Fiona Gibson - MOD 3 Stage 1 Discovery Point - Request for additional information

From: Marta Gonzalez-Valdes <MGonzalez@rockdale.nsw.gov.au>
To: <Fiona.Gibson@planning.nsw.gov.au>
Date: 21/01/2014 5:08 PM
Subject: MOD 3 Stage 1 Discovery Point - Request for additional information
Attachments: IGA_7_11_2013_12_30_3_932.pdf

I refer to the DP&I notification to Council of the above modification and thank you for the opportunity to comment. Council's engineer has reviewed the information submitted and raised the following issues that would require additional information:

ELECTRICAL & HYDRAULIC SERVICES
INFRASTRUCTURE
MASTER PLAN -
OPTION A

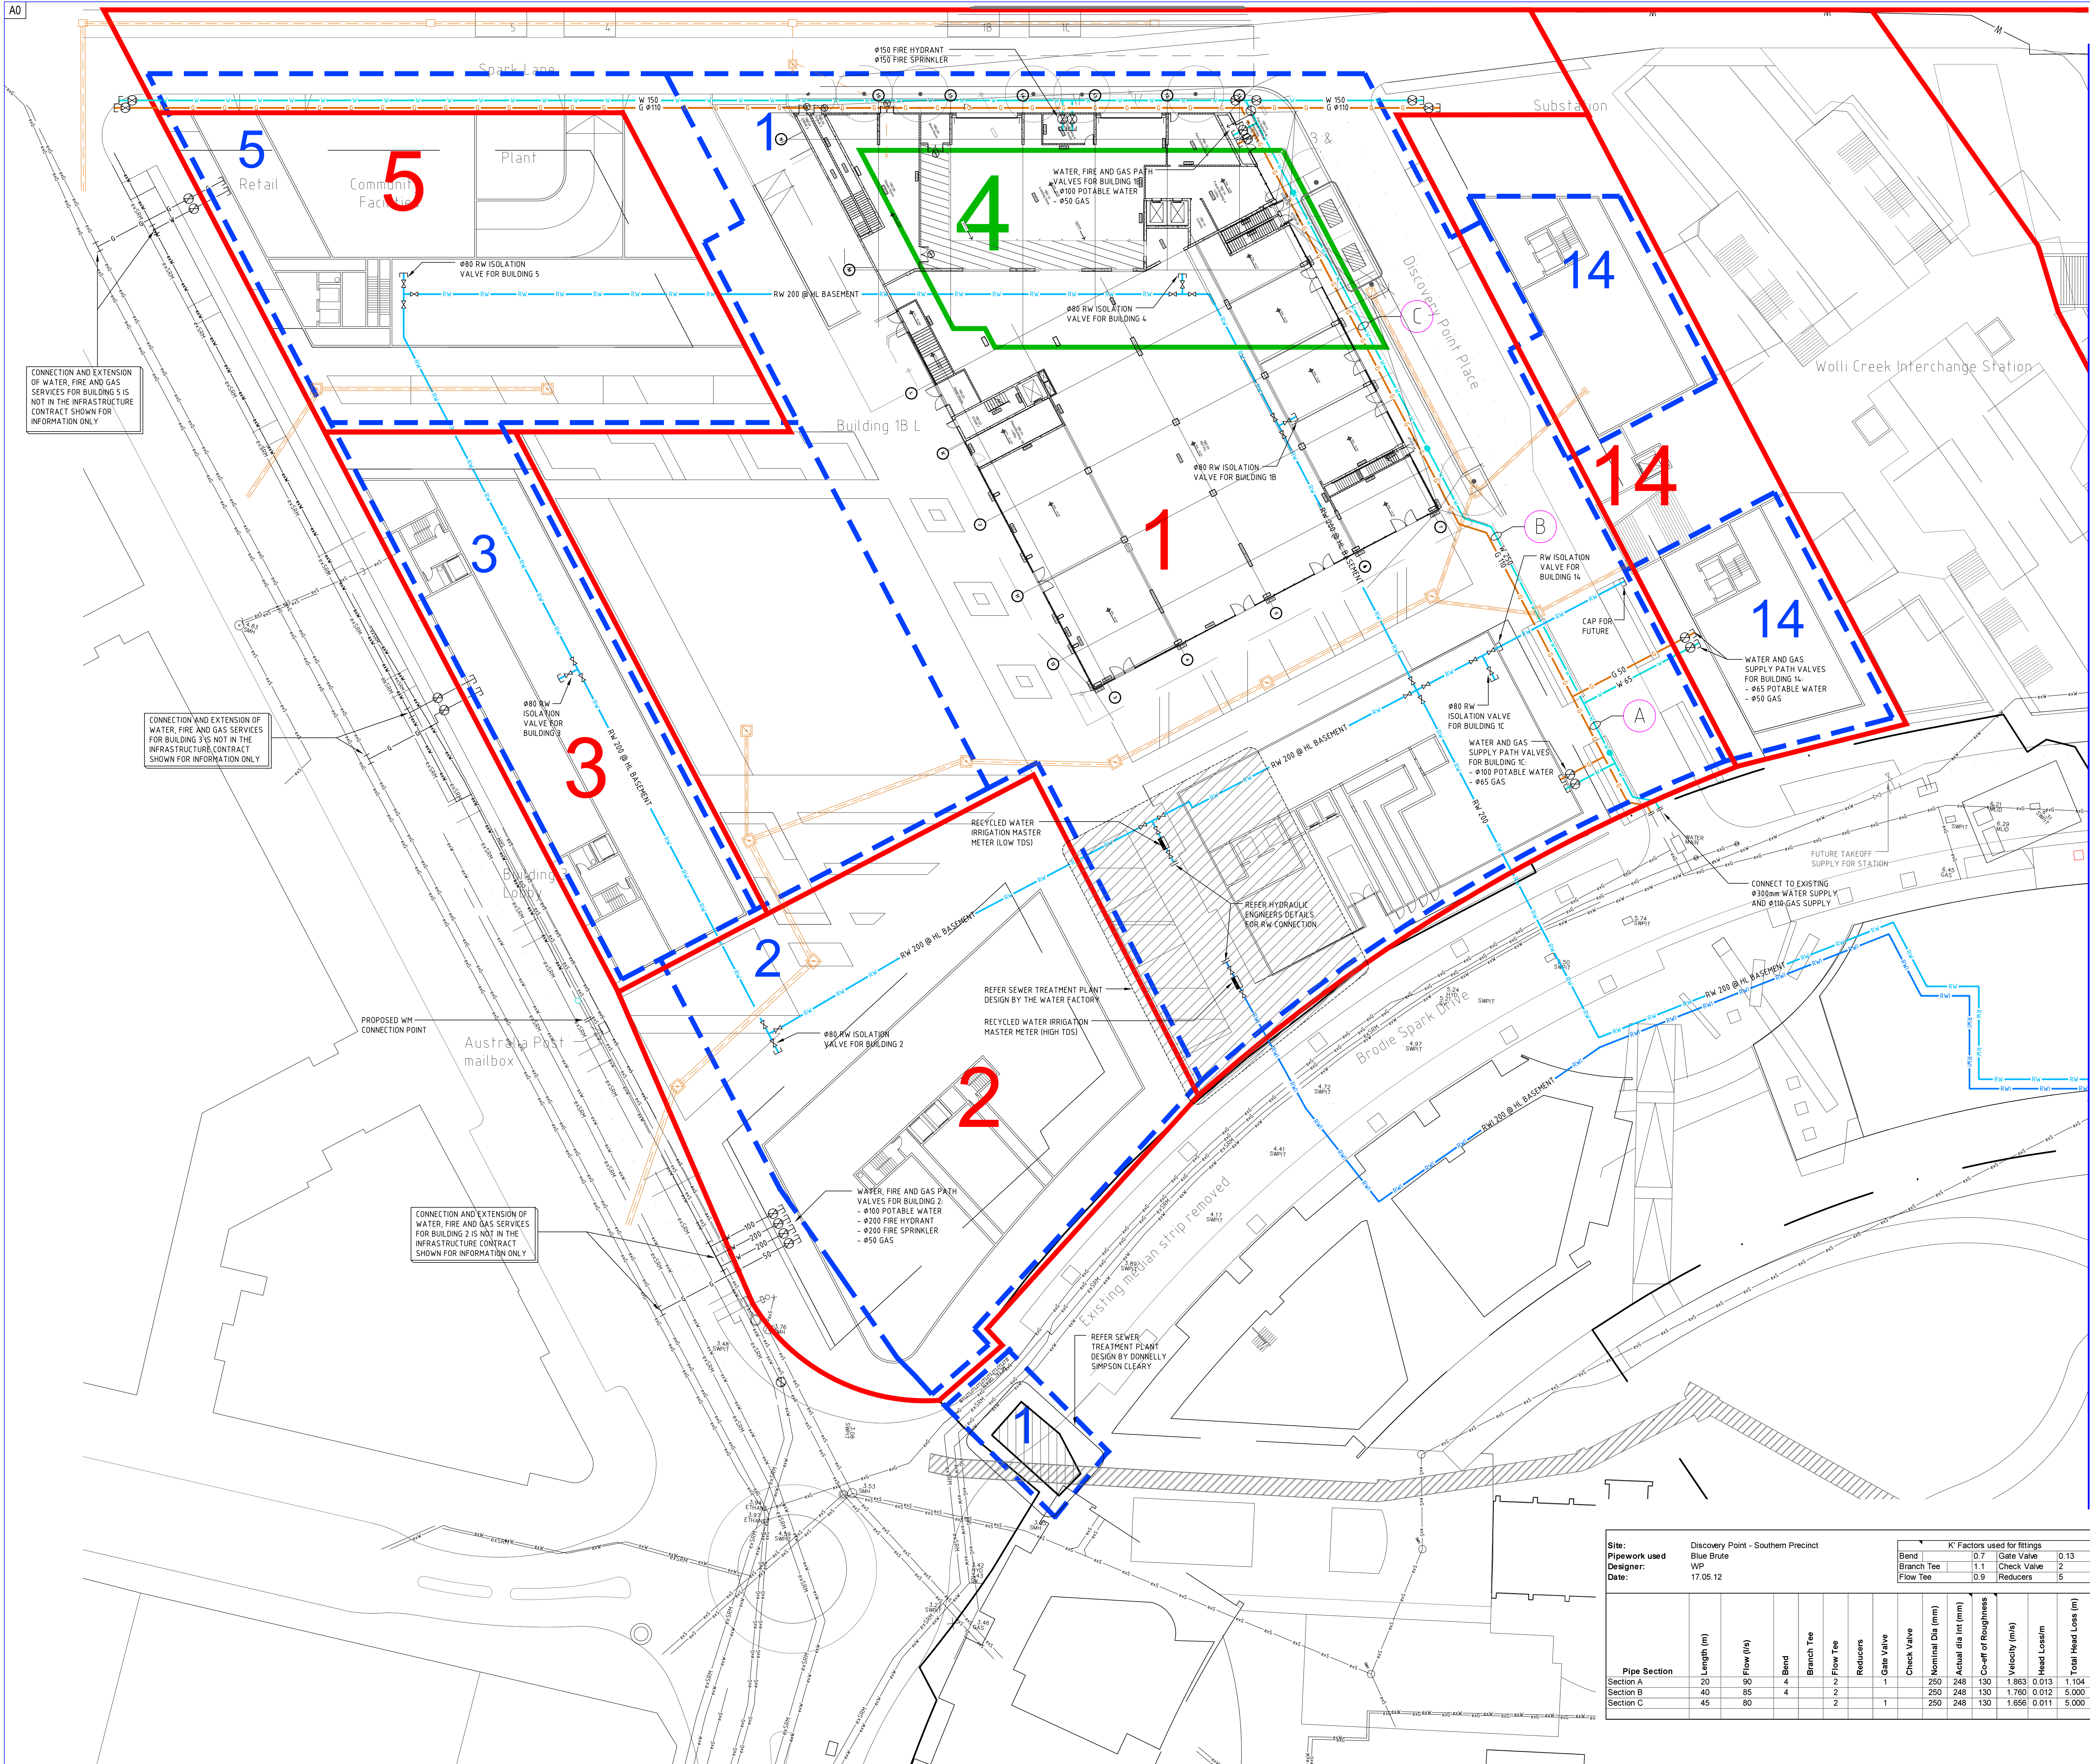
1. The road dedication on the corner of Magdalene Terrace and Spark Lane shall be shown and proposed changes to original approved plans, dated 26/09/11 are to be identified to better understand the proposal. The subdivision plans must be consistent with the sketch attached to this email.
2. The proponent to provide clarification for easements / restrictions which are to be released.
3. In regard to the recycled water reticulation system/infrastructure, clarification is to be provided as follows:
 - a) The design engineer to certify the proposed system, mainly the proposed staged operation of the system.
 - b) Sydney Water to provide comments on the proposal for the DP&I consideration.
 - c) If the plans are to be listed in the consent, reference to electrical services should not be detailed on the plans.
